**Substantive response of the Local Highway Authority to a planning consultation received under The Development Management Order.**

Planning Application Number: 23/1004/DOC

Application Address: Trent Pottery Co Regent Street Narborough Leicestershire LE19 2DJ

Discharge of conditions No. 4 (Lighting and CCTV), 5. (Cycle Parking), 8. (Construction Method Statement) and 12. (Landscaping Scheme) in relation to permission 23/0385/FUL.

| DRAWING TITLE: PROPOSED CYCLE PARKING | | | | | |

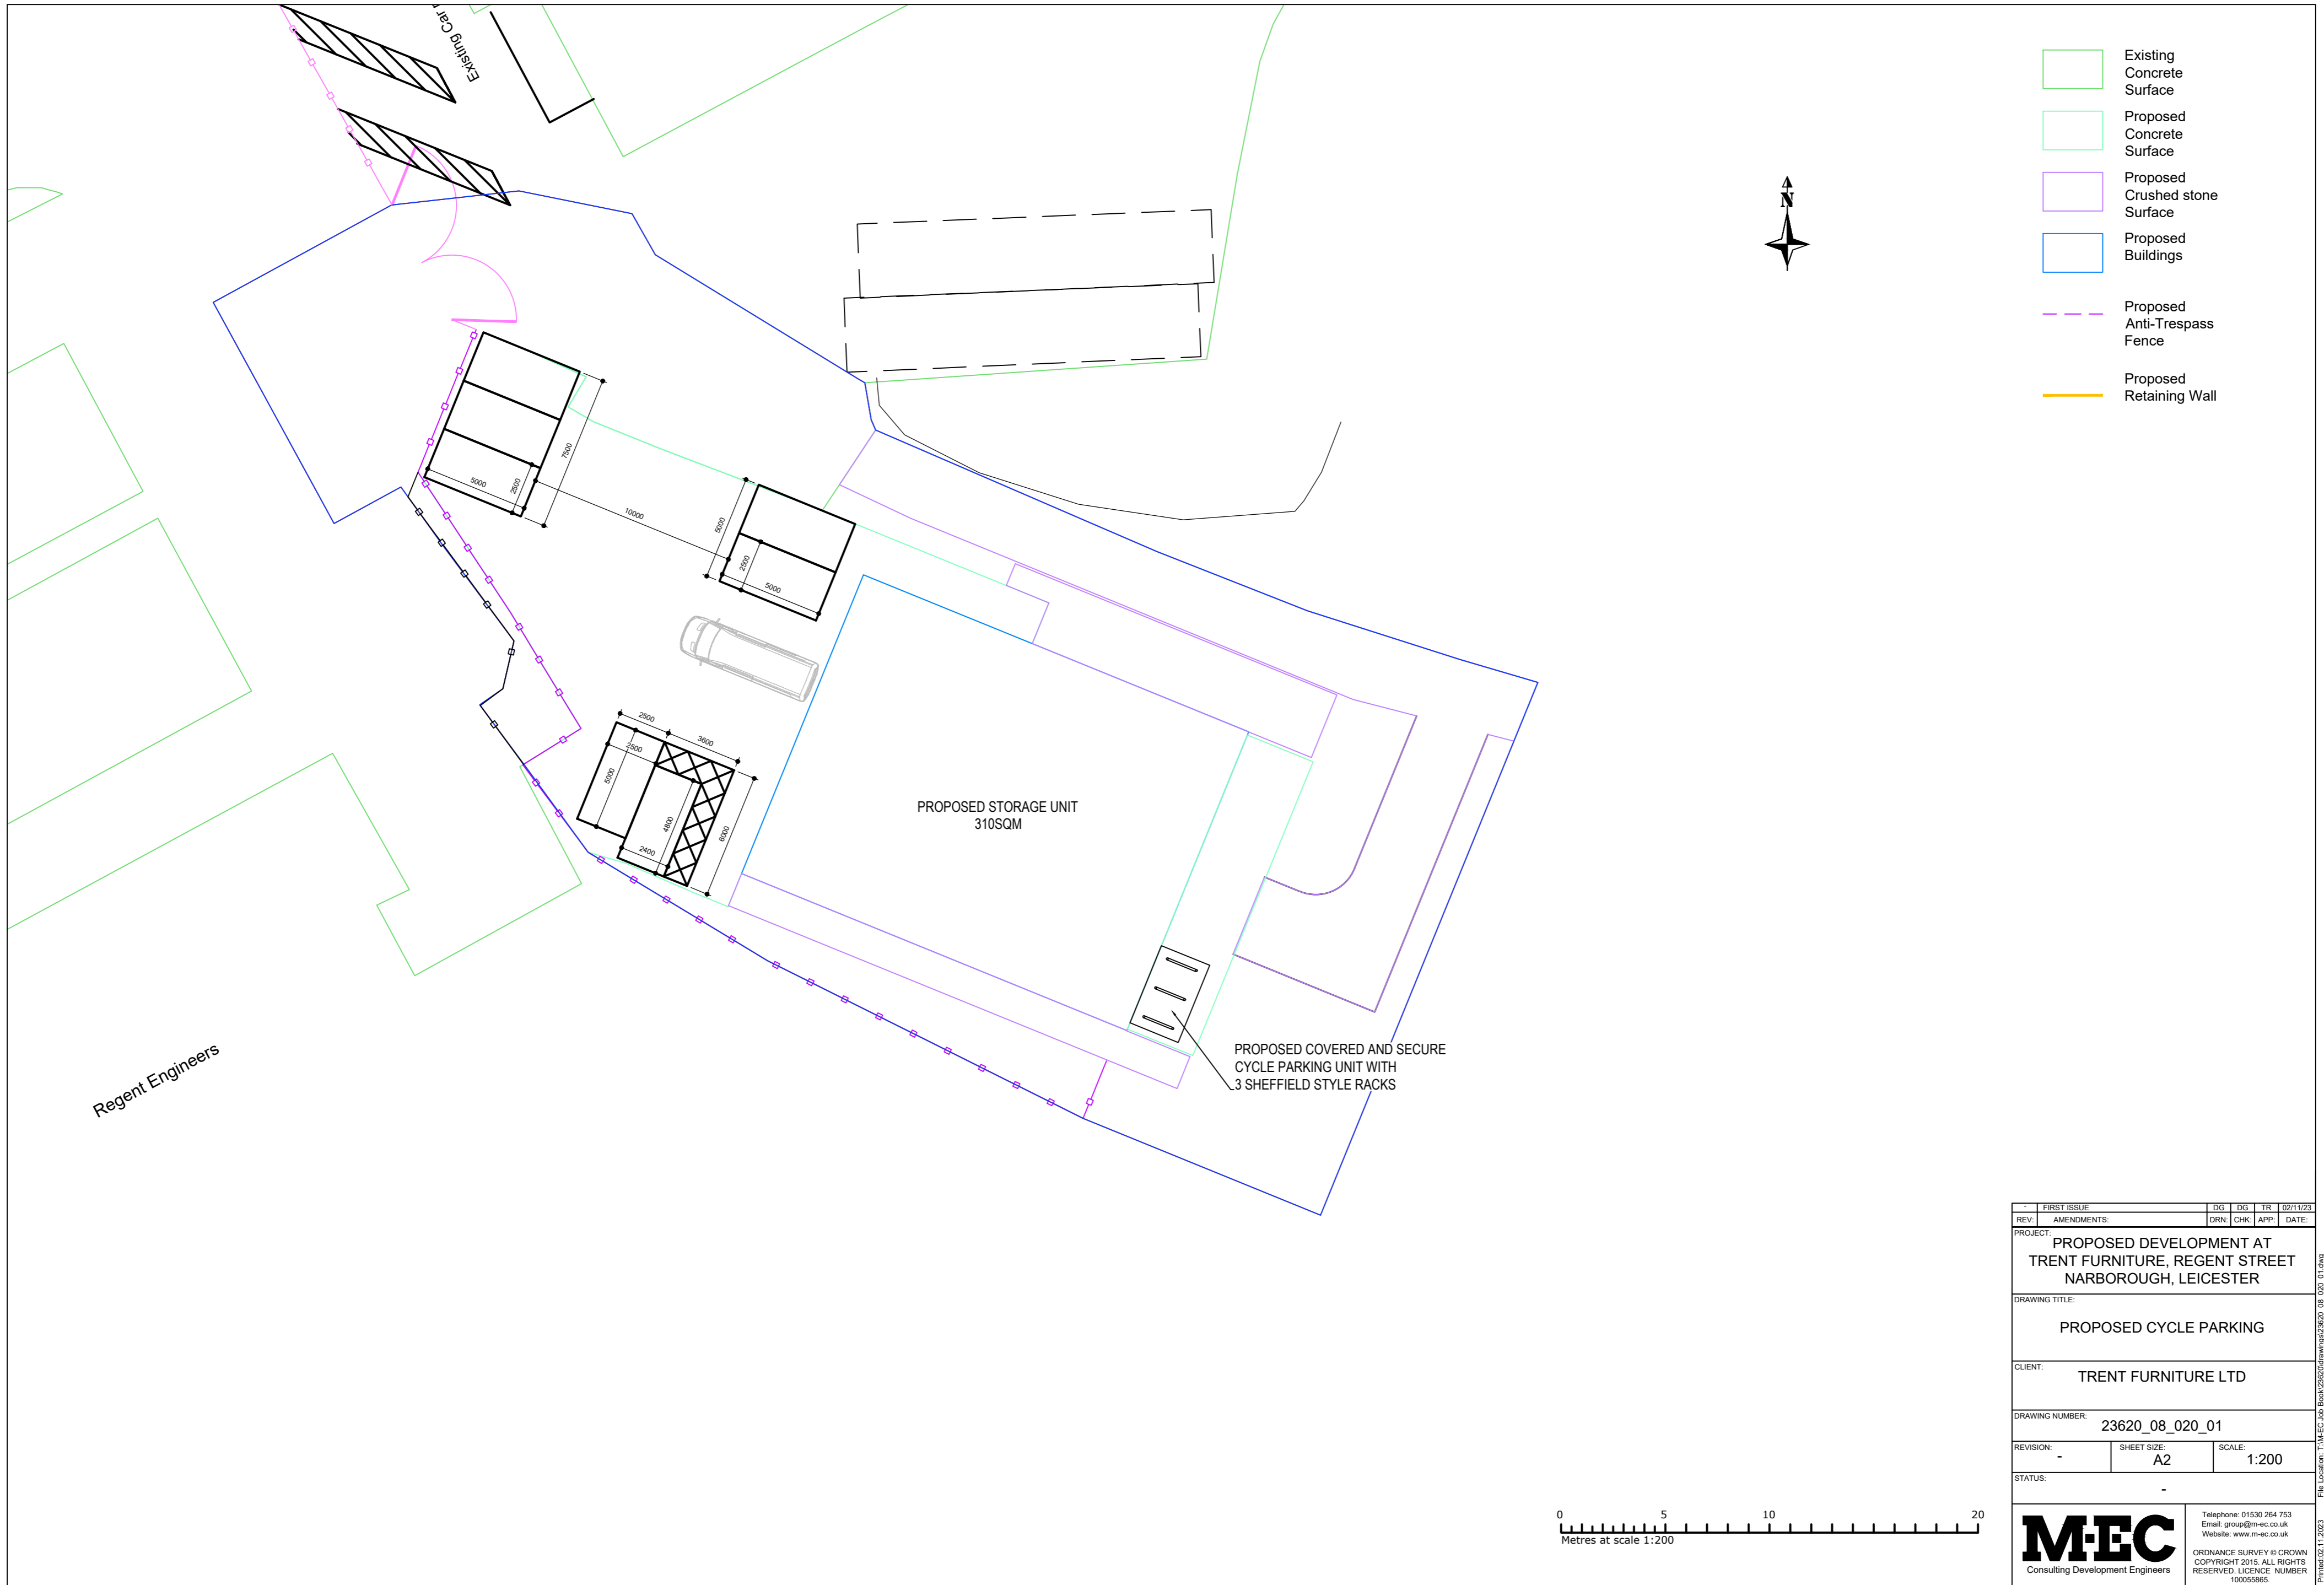
The 'Proposed Cycle Parking' drawing (MEC, drawing number 23620\_08\_020\_01) shows a Bike Cycle Shelter shown on site. As per 3.179 of the Leicestershire Highways Design Guide (LHDG) - all cycle parking should be secure and normally with weather protection provided at least for employee parking. The LHDG also recommends Sheffield Stands as illustrated by DG16 of the LHDG.

The applicant has demonstrated the cycle shelter will be covered, secure and consist of Sheffield Stands. However, the LHA request the facilities be relocated so they are more conveniently located at entrances to buildings, enjoy good natural observation and be well lit in accordance with 3.179 of the LHDG part 3.
